Application for a non-material amendment following a grant of planning permission.  
Town and Country Planning Act 1990

House name: **FORMER MOORCOCK INN SITE**

CONSTRUCTION OF FOUR DWELLINGS INCLUDING ASSOCIATED DRIVES,  
GARDENS AND EXTERNAL LANDSCAPE WORKS

3/2018/0344

5513 - P02C

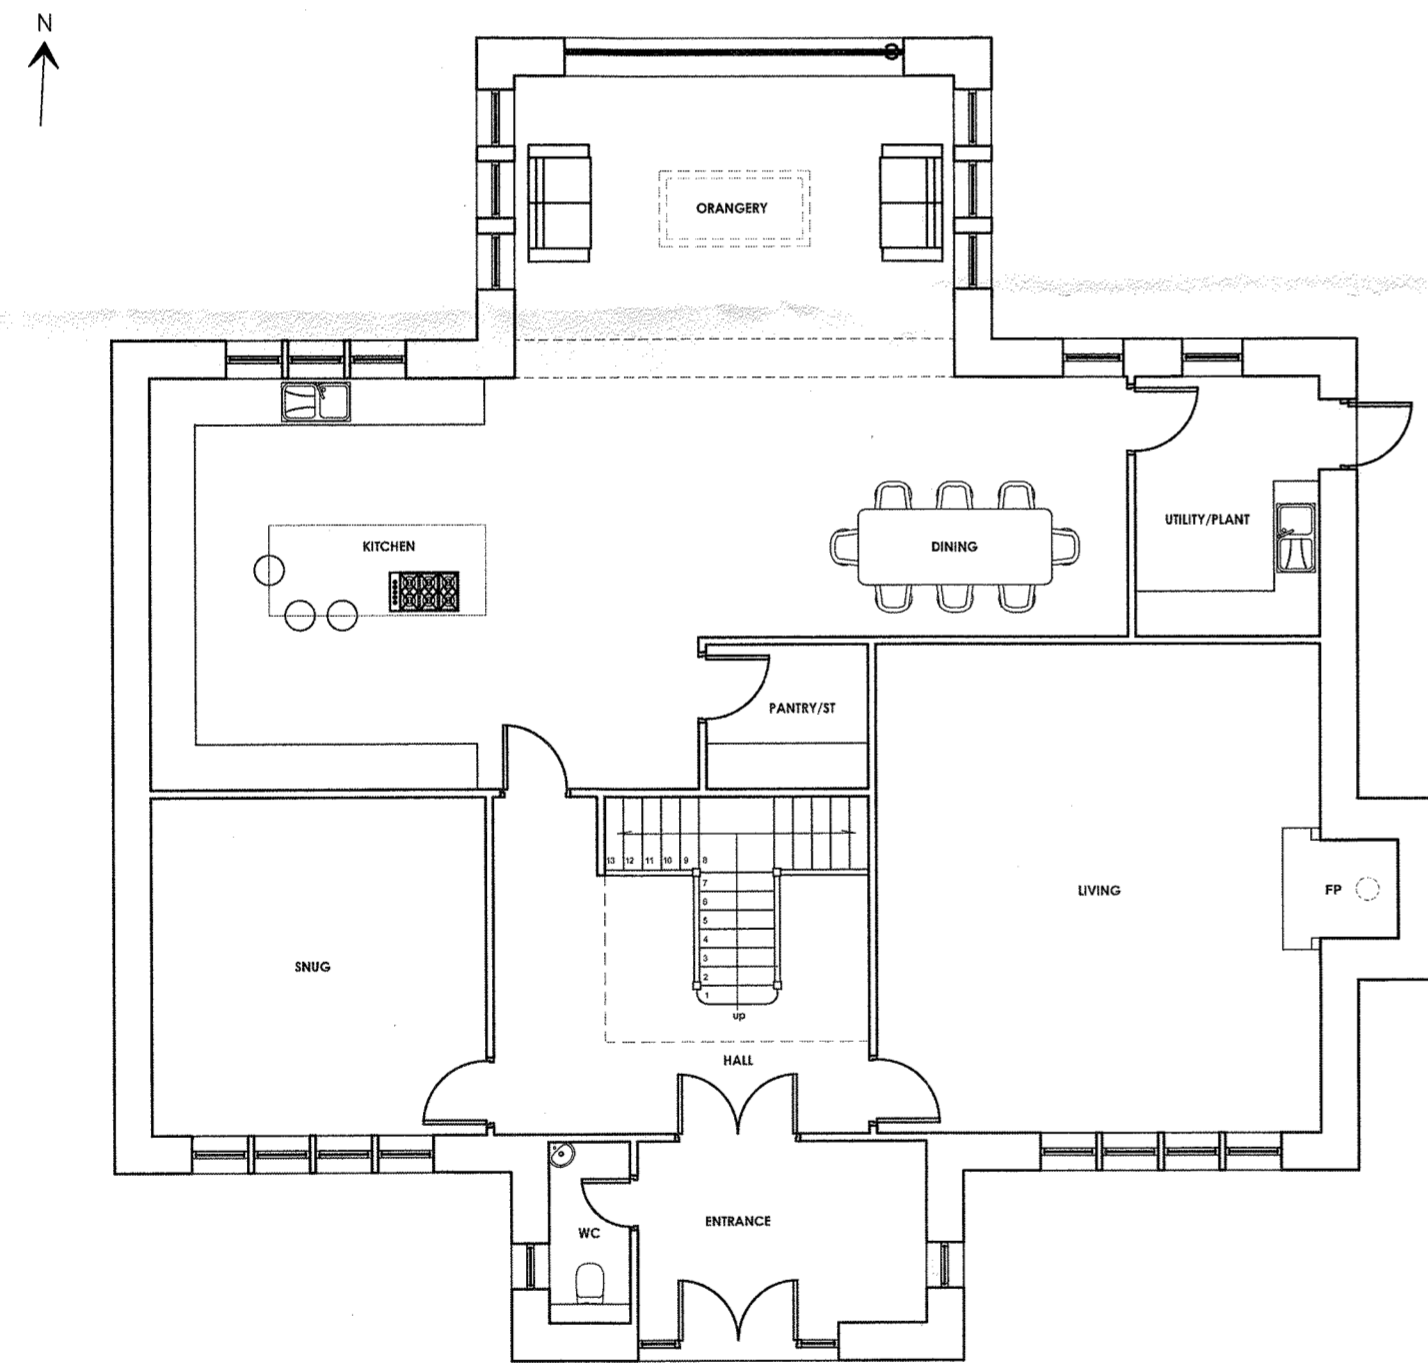
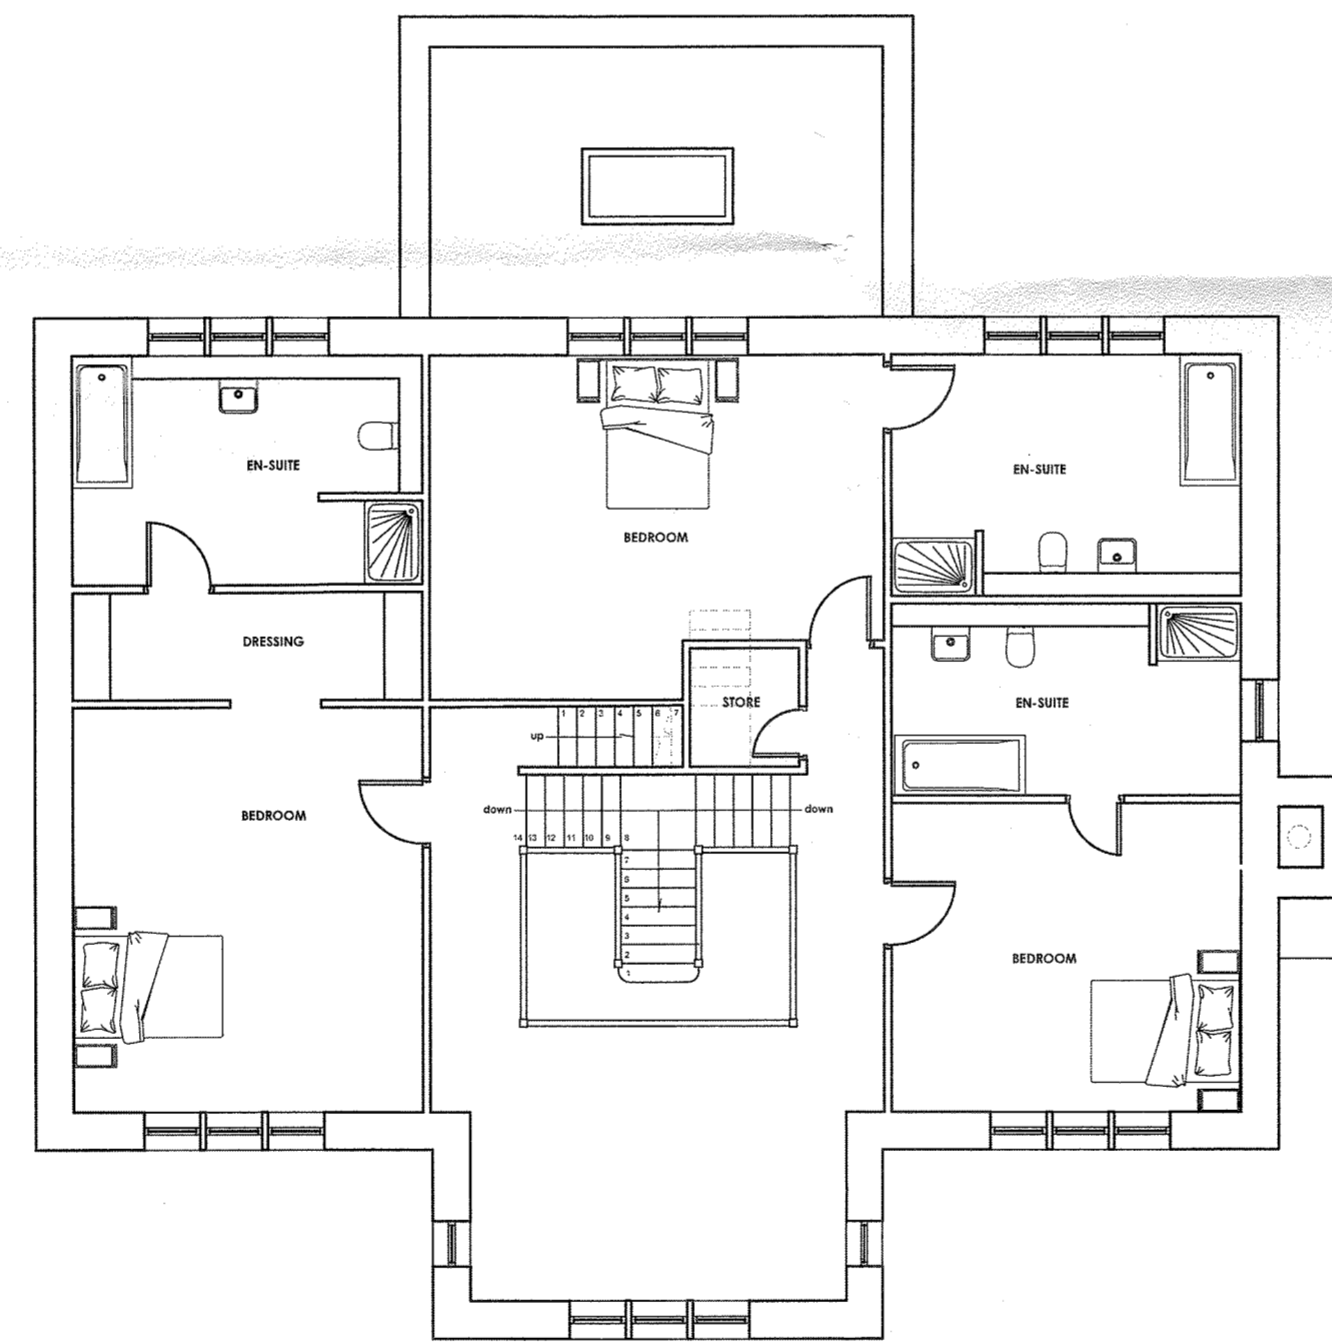
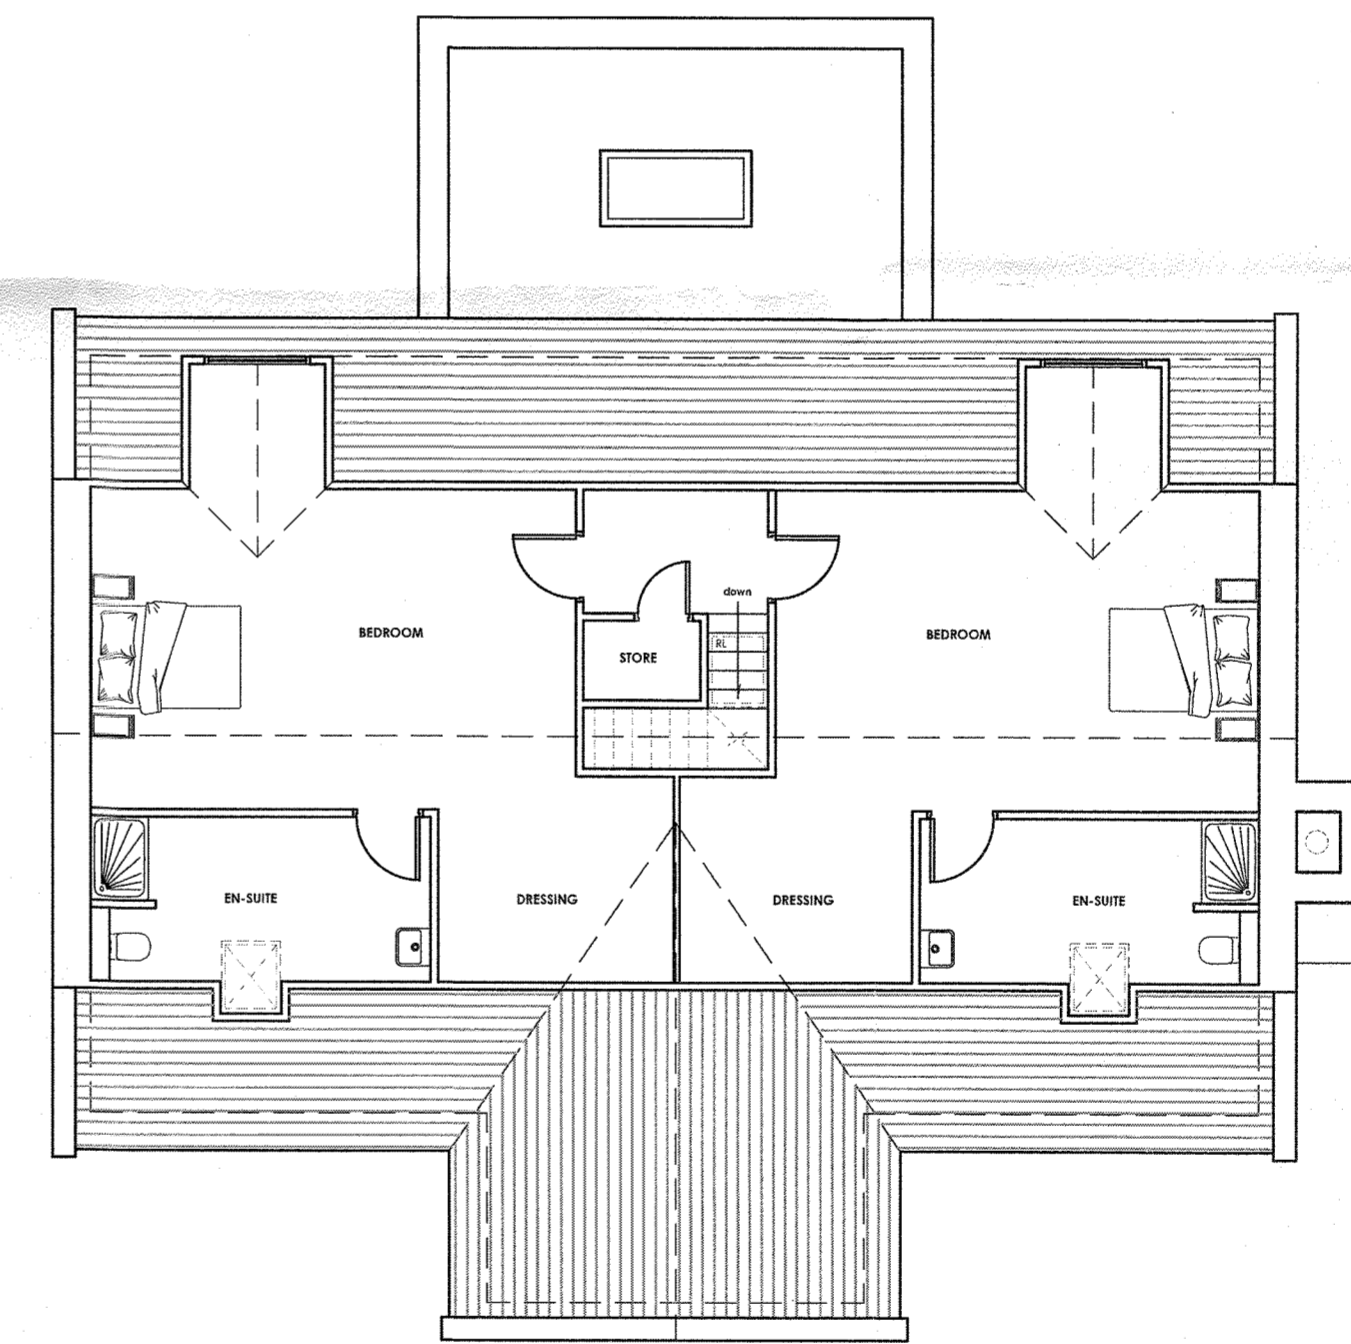
- PLOT 4:  
• WINDOWS ADDED TO THE FRONT GABLE  
• WINDOW ADDED TO EN-SUITE
- PLOT 3:  
• WINDOWS ADDED TO THE FRONT GABLE  
• WINDOW ADDED TO EN-SUITE
- PLOT 2:  
• WINDOW ADDED TO EN-SUITE
